El Paso County
STORMWATER MANAGEMENT PLAN

Short Stop Restaurant
Part of Lot 1, Powers Centre Filing No. 3
Section 6, Township 14 South, Range 65 West of the 6th P.M.
5819 Palmer Park Boulevard

Revised
November 28, 2018

SUBJECT: Stormwater Management Plan
Short Stop Restaurant

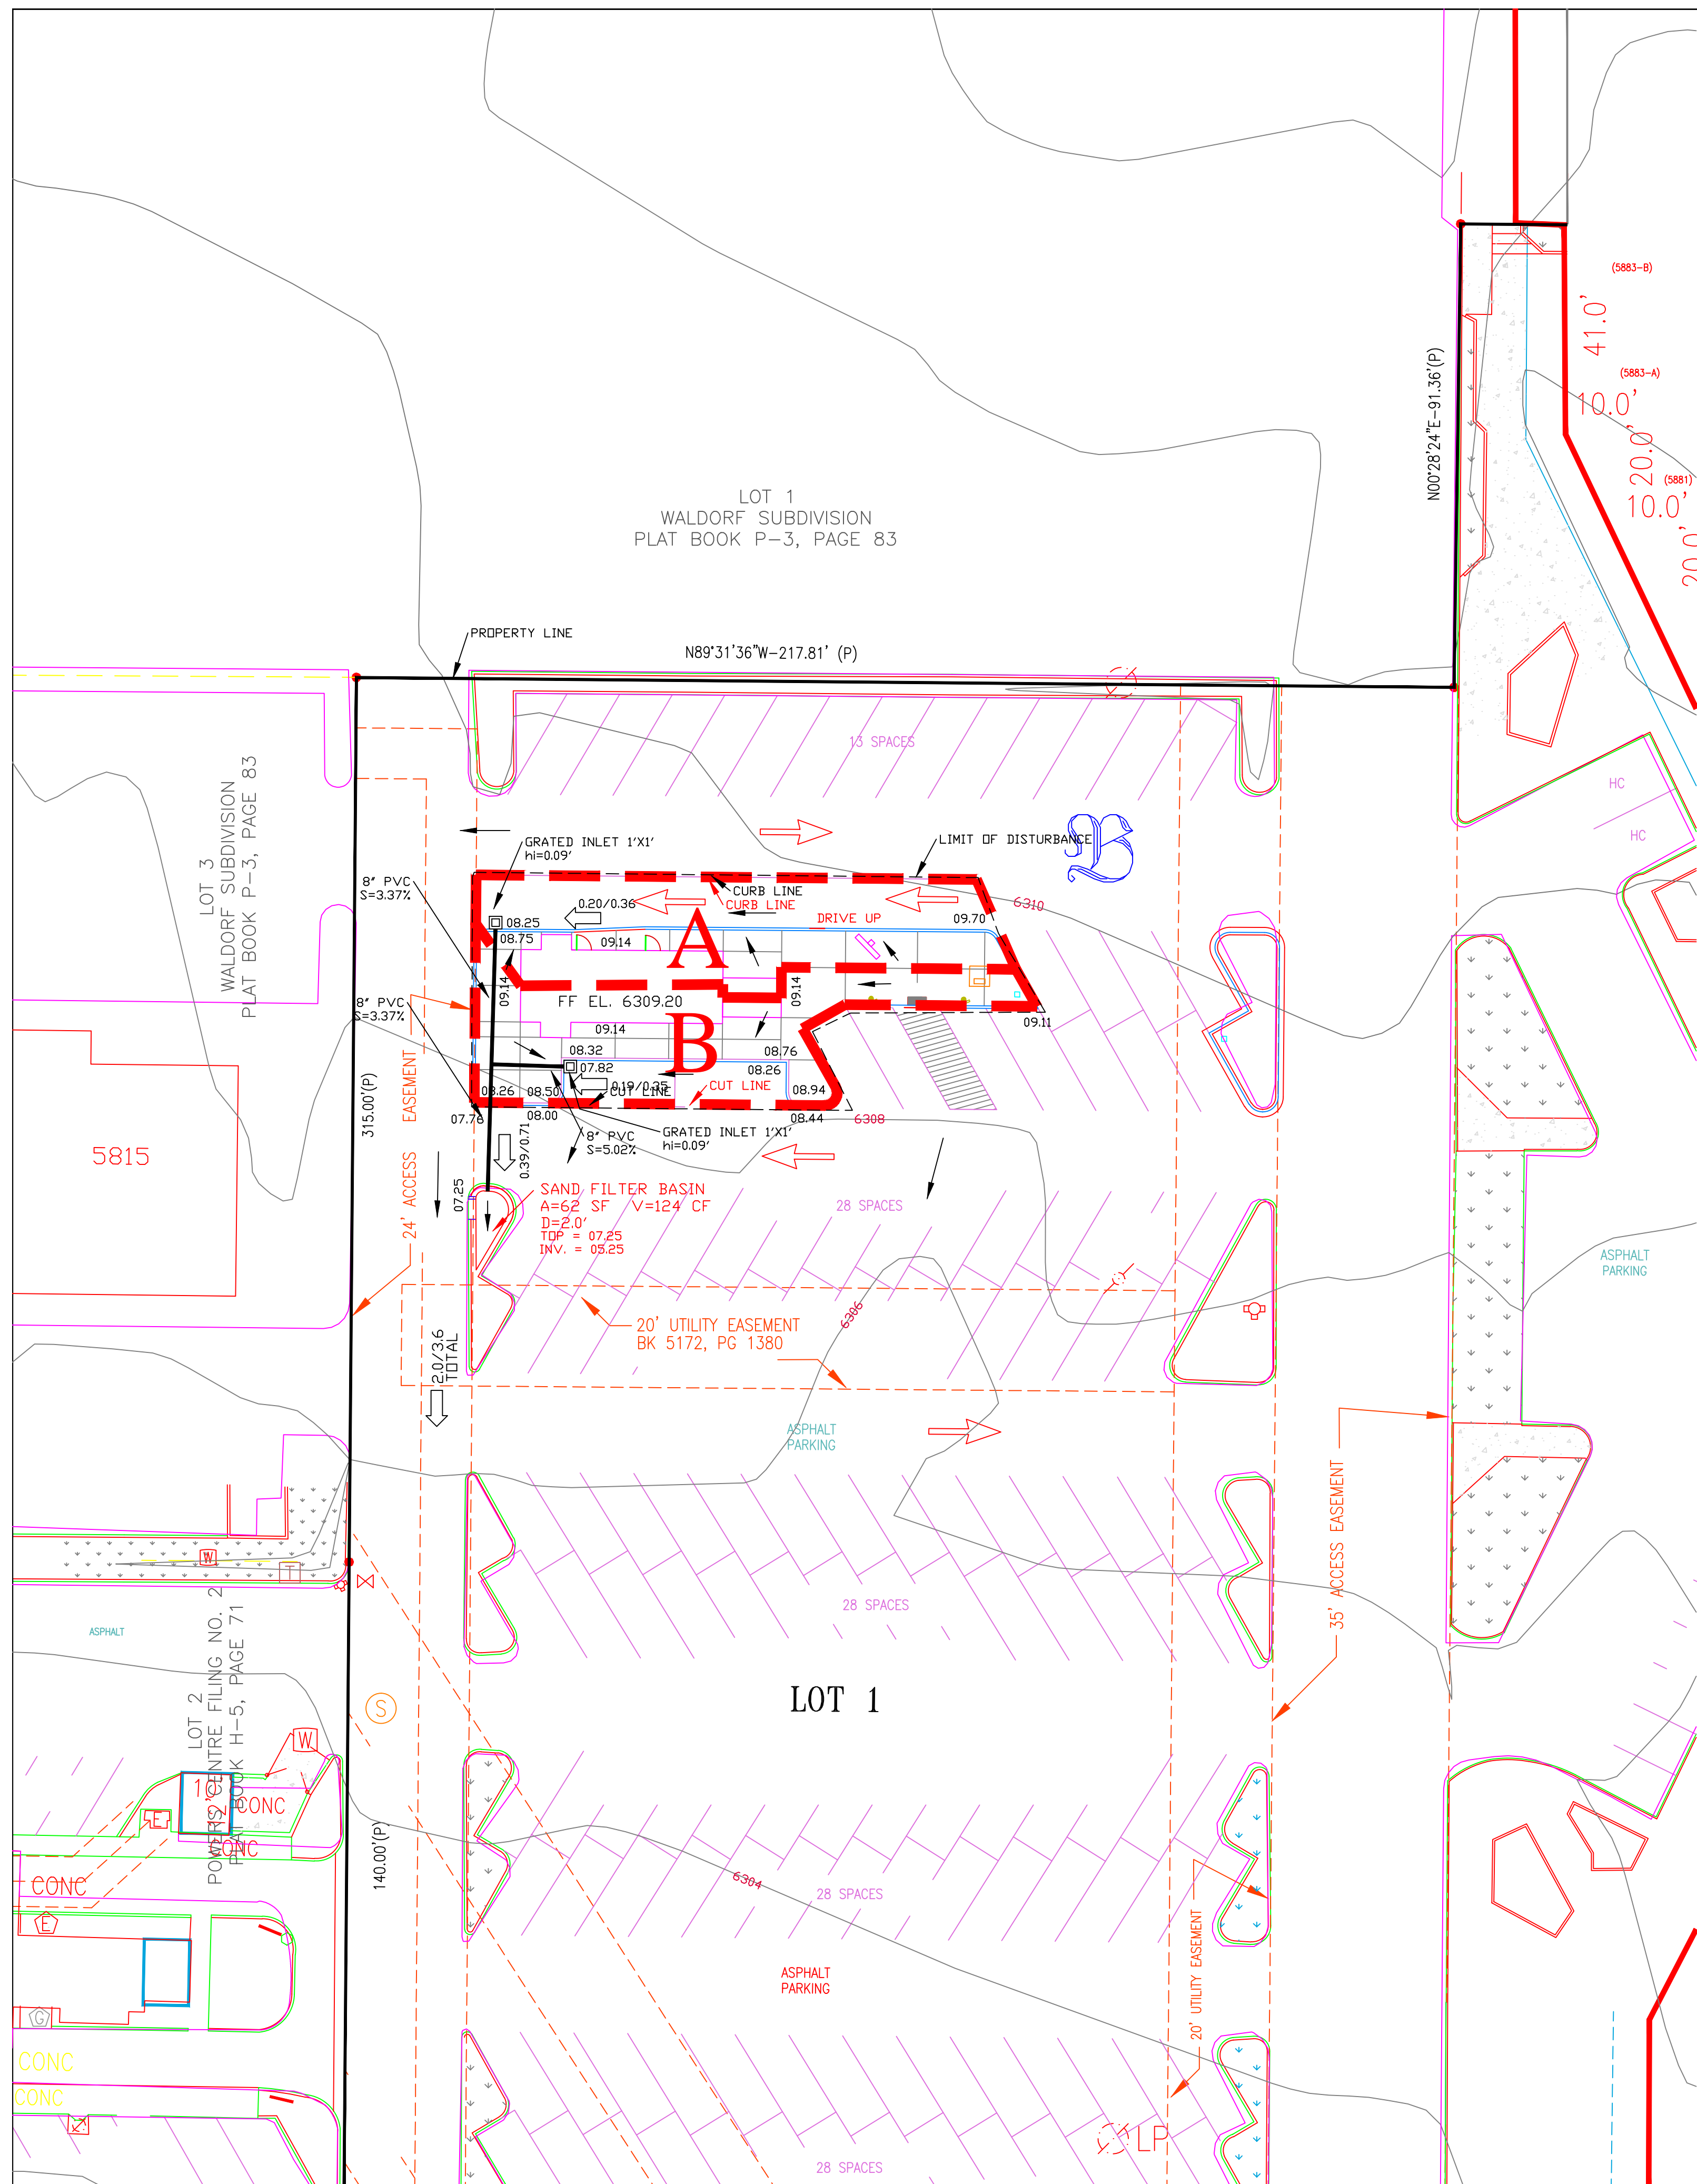
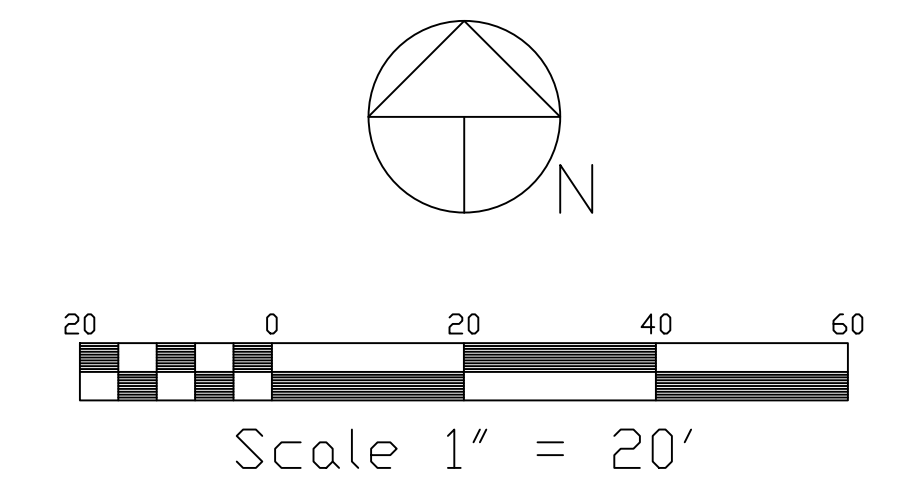
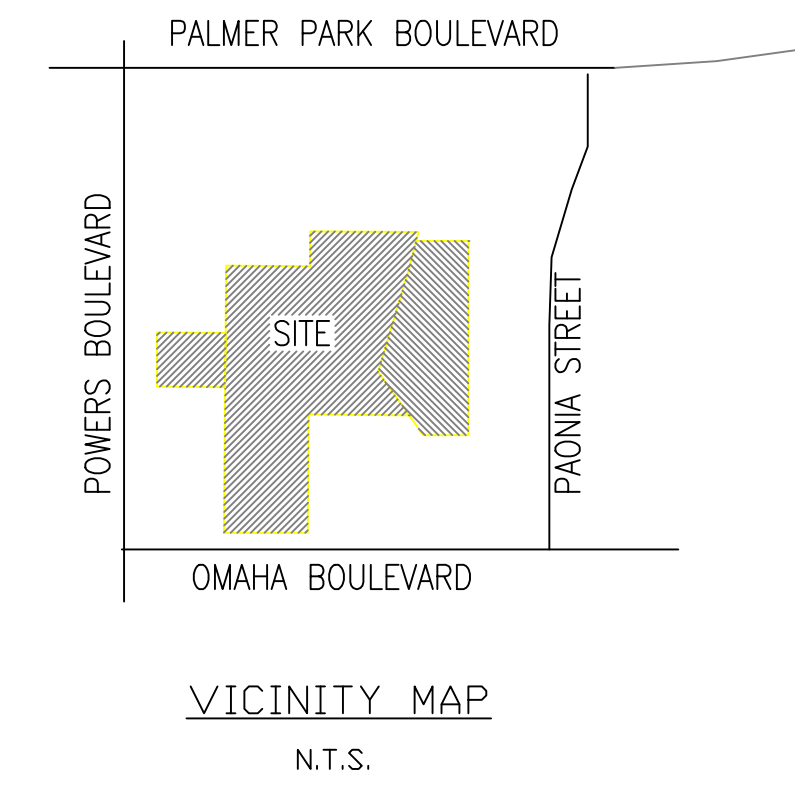
Please revise the text so that it matches the design shown on the drainage report.
